Ribble Valley Borough Council  
Housing & Development Control

Your ref 3/2022/0677  
Our ref D3.2022.0677  
Date 30<sup>th</sup> August 2022

Application no: **3/2022/0677**

Proposal: **Proposed new tiled roof to conservatory, single storey front and side extensions to create additional living accommodation.**

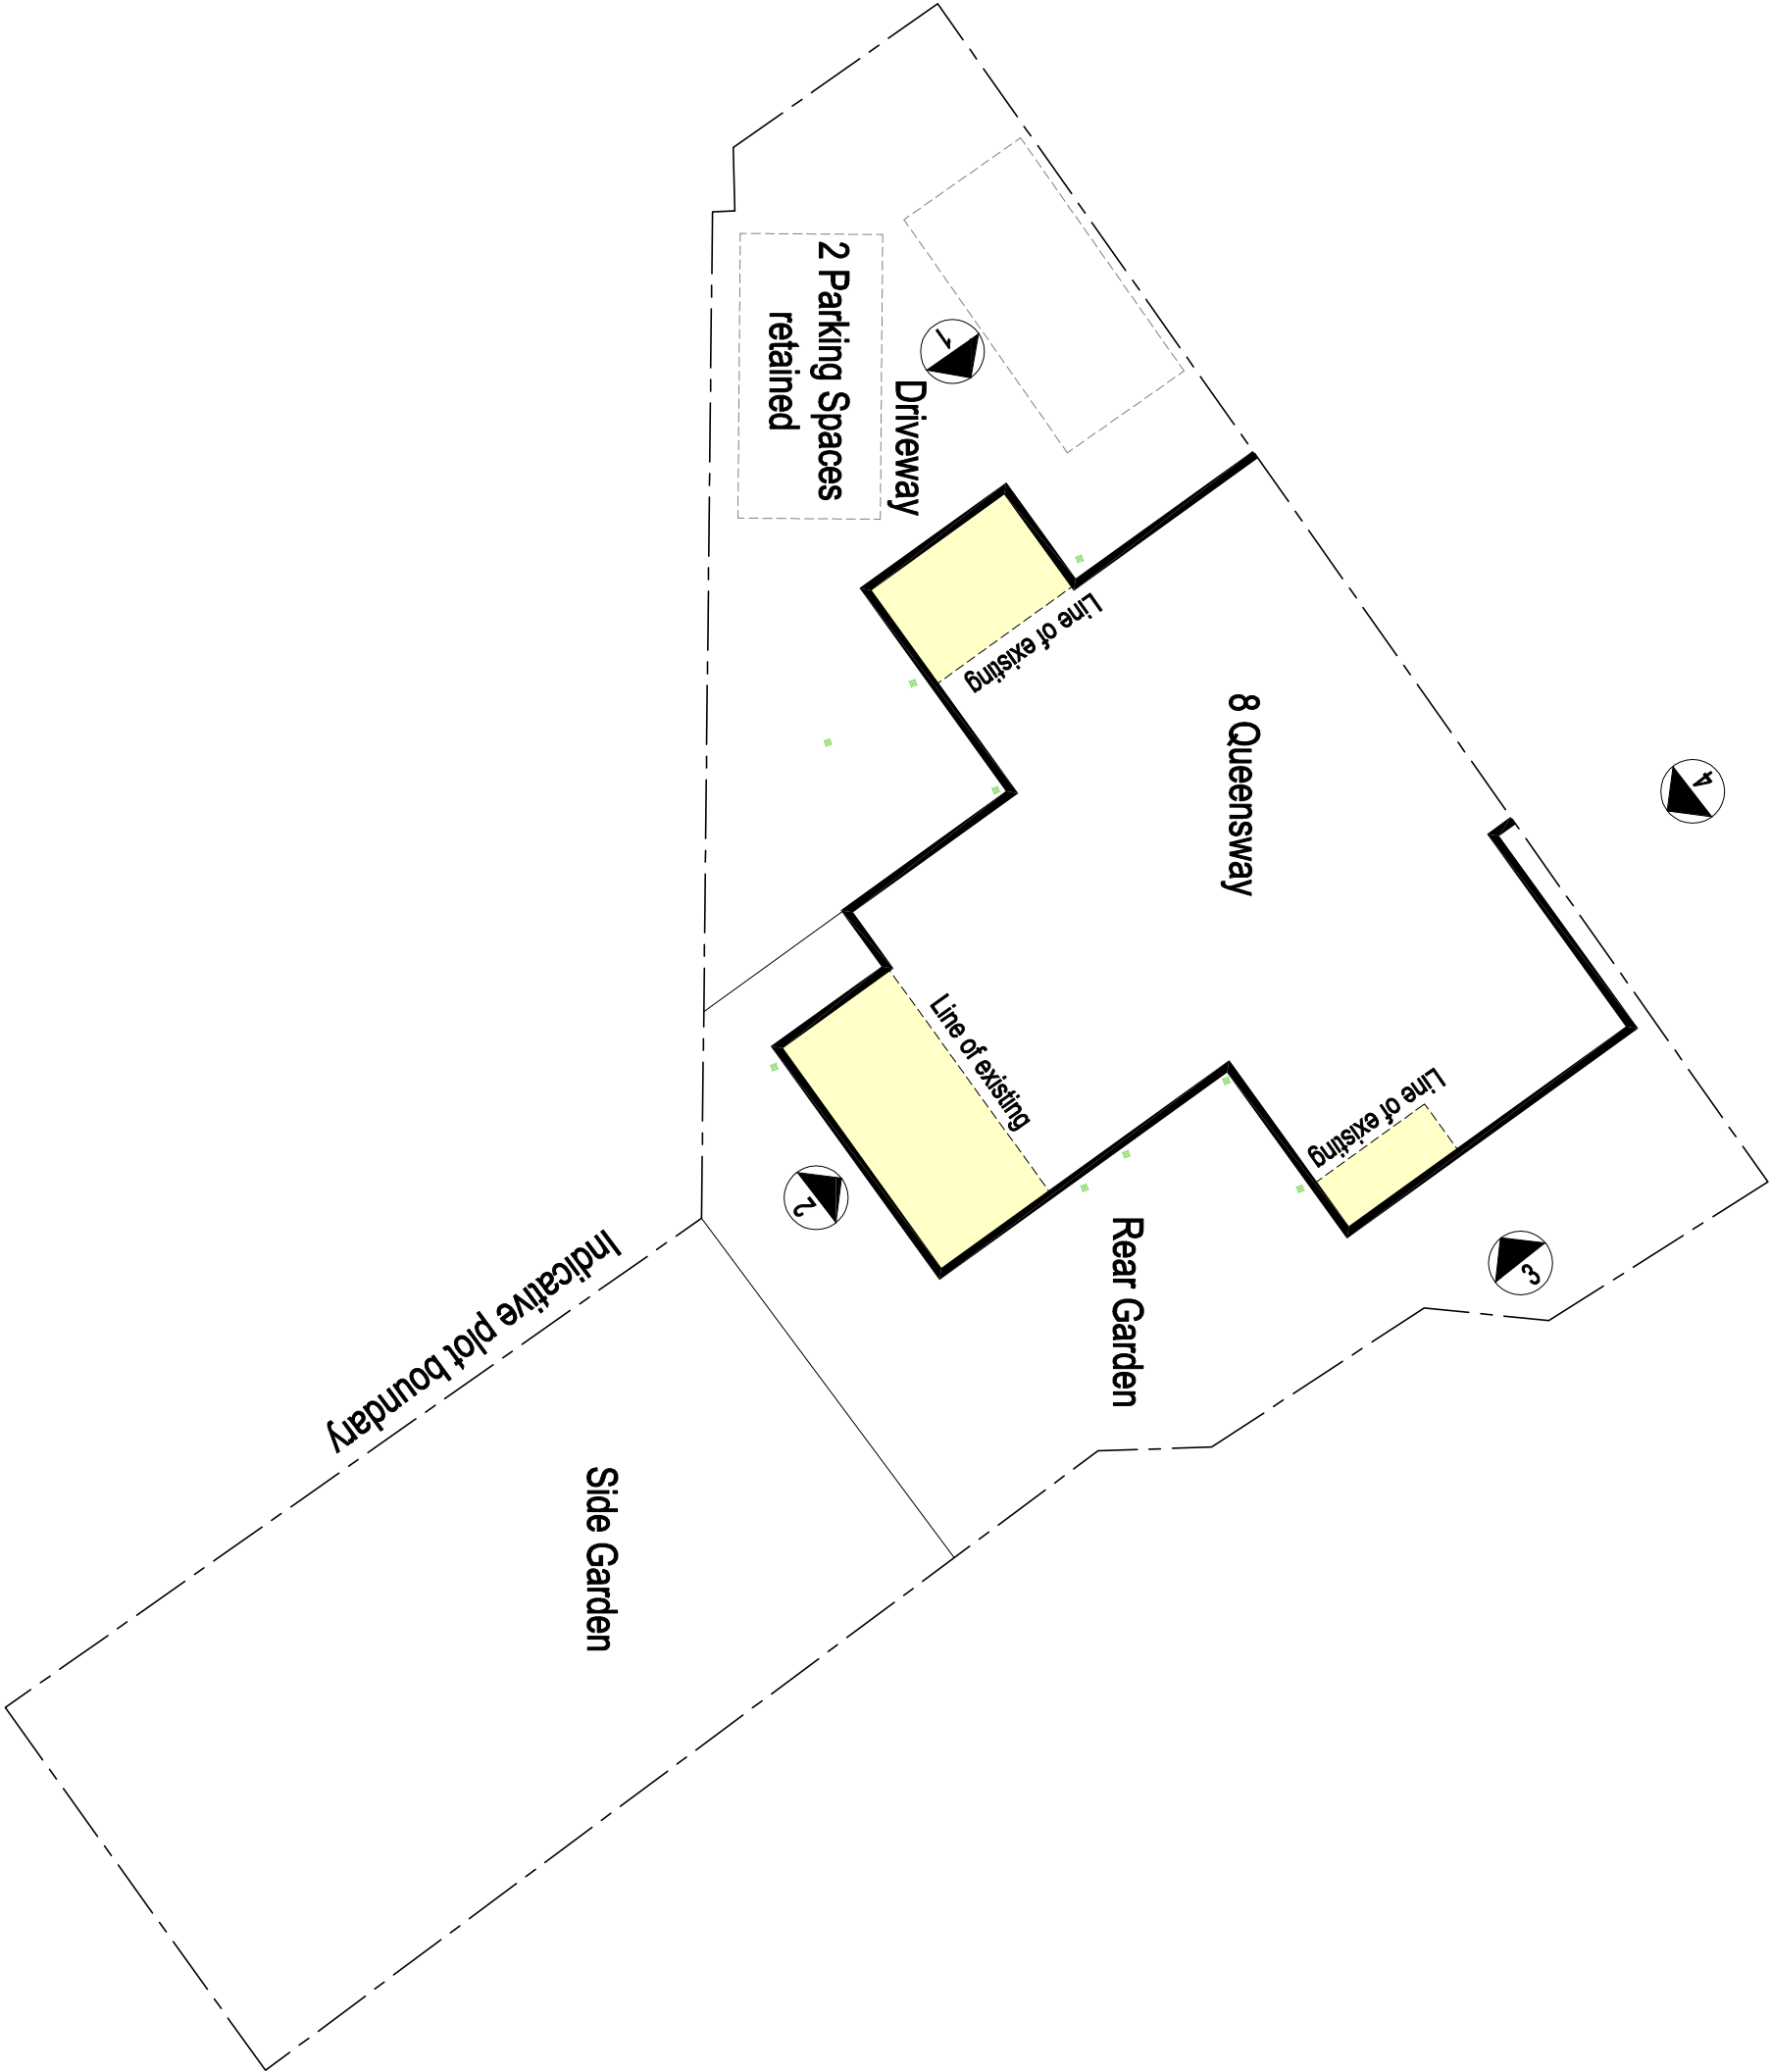
The LHA previously responded to the application on 5th August 2022 requesting further information regarding the parking arrangements at the site. Since then a revised drawing has been submitted which is shown on AW+A drawing number PL/05 Rev A titled "Proposed\_Site\_Block Plan" and this will be reviewed below.

The LHA have reviewed AW+A drawing number PL/05 Rev A titled "Proposed\_Site\_Block Plan" and are aware that 2 car parking spaces will be provided for the 4-bed dwelling. However, this does not comply with the LHAs parking guidance as defined in the Joint Lancashire Structure Plan which requires a 4-bed dwelling to provide 3 car parking spaces.

Despite this, the LHA will accept the shortfall in parking in this case. This is because off-street parking already occurs on Queensway and so is a pre-existing situation and the addition of one further vehicle will not exacerbate the current highway situation given that no parked vehicles will conflict with any neighbouring dwellings access and driveway.

The development hereby permitted shall not be occupied until such time as the parking and turning facilities have been implemented in accordance AW+A drawing number PL/05 Rev A. Thereafter the onsite parking provision shall be so maintained in perpetuity.
